January 2024

Application no: 23/02098/OUT

Proposal: Outline application, with all matters reserved, for a multi-phased (severable), comprehensive residential-led mixed use development comprising: Up to 215,000 square metres gross external area of residential floorspace (or c.1,800 homes which depending on the housing mix could result in a higher or lower number of housing units) within Use Class C3/C4 and large houses of multiple occupation (Sui Generis); Supporting social infrastructure including secondary school/primary school(s) (Use Class F1); health, indoor sport and recreation, emergency and nursery facilities (Class E(d)-(f)). Supporting retail, leisure and community uses, including retail (Class E(a)), cafes and restaurants (Class E(b)), commercial and professional services (Class E(c)), a hotel (Use Class C1), local community uses (Class F2), and other local centre uses within a Sui Generis use including public houses, bars and drinking establishments (including with expanded food provision), hot food takeaways, venues for live music performance, theatre, and cinema. Up to 155,000 net additional square metres (gross external area) of flexible employment uses including re

Policy PR8 – Policies Map – Land East of the A44

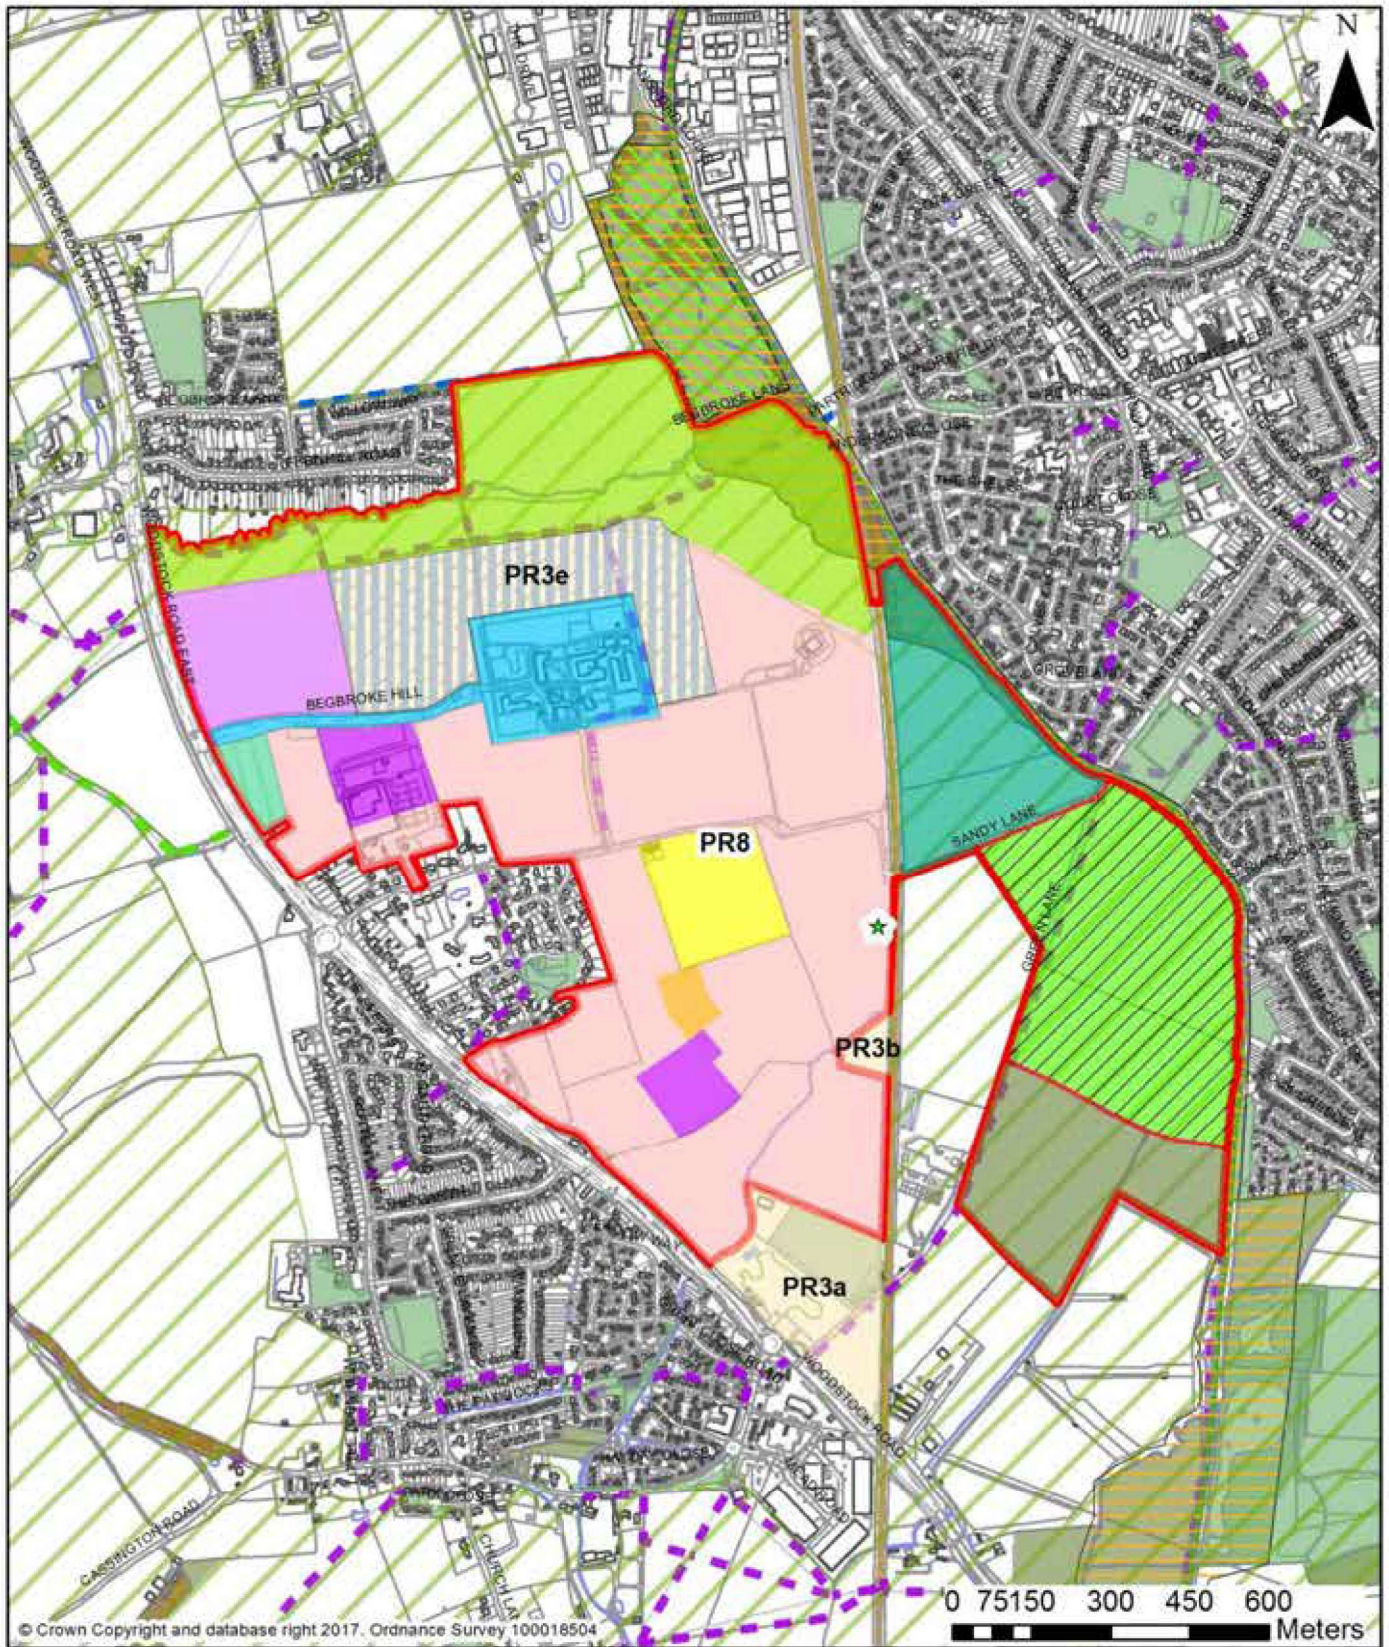
The map titled **Policy PR8 Policies Map – Land East of the A44** indicates the location of the proposed Local Nature Reserve across the northern edge of the development site.

We are very concerned that the current application proposes that the area indicated as a 29ha LNR in the local plan will include a community farm, allotments and a community orchard along with a greatly reduced area for nature which includes a woodland in the west transitioning through wildflower-rich meadows and then wetland and marsh habitats in the east (see Design and Access Statement part 7 5.15). The applicant's Outline Landscape and Ecological Management plan (OLEMP) states (p11):
